REF: SAN PASQUALE PLACE

RE: REVISED GRADING & DRAINAGE PLAN FOR SAN PASQUALE TOWNHOUSES  
(J13-D20) RECEIVED AUGUST 30, 1984

The above referenced plan, dated August 29, 1984, is approved.

TITLE DRAINAGE AND GRADING PLAN
PROJECT SAN PASQUALE TOWNHOUSES
DATE 7-18-84
DRAWN [Signature]
CHECKED [Signature]

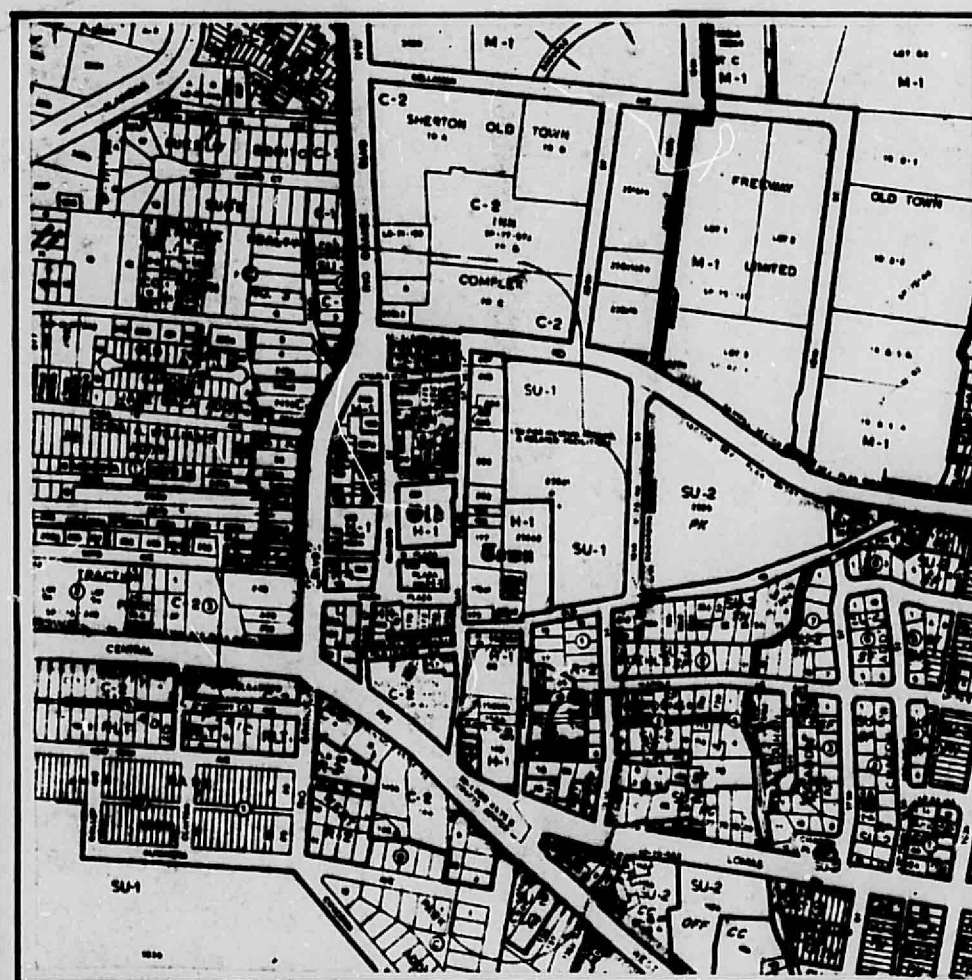
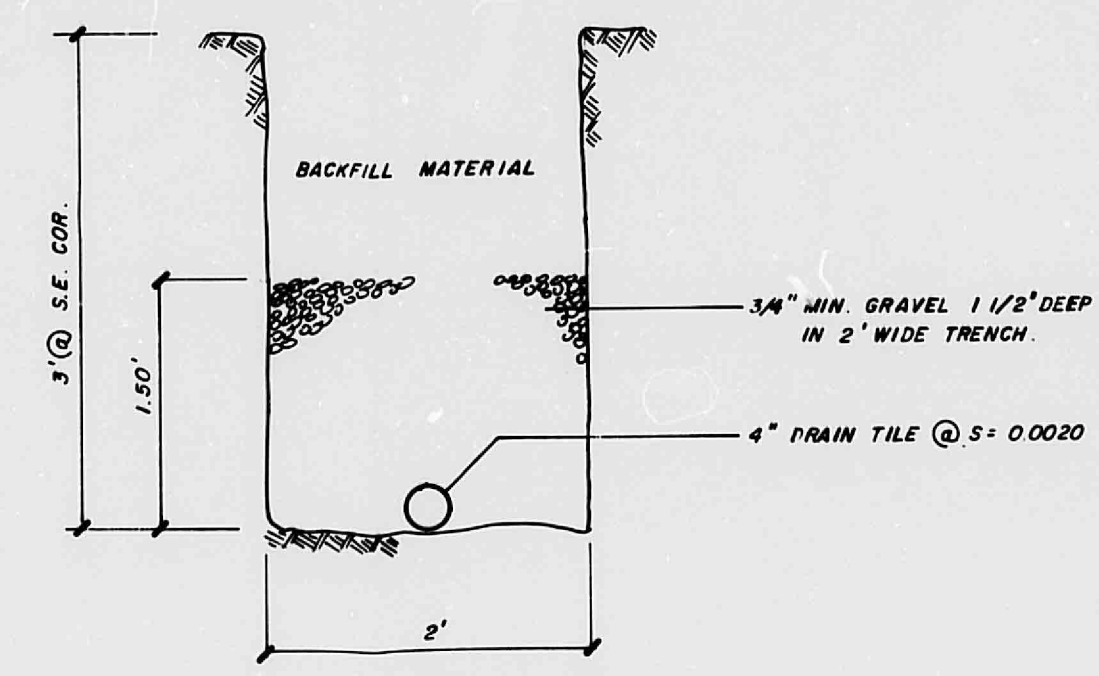
Also, be advised that prior to sign-off for the Certificate of Occupancy (C.O.) you will need to furnish this office with a copy of the recorded plat showing a drainage easement along the back side of the lots where the 4-inch drainline is located.
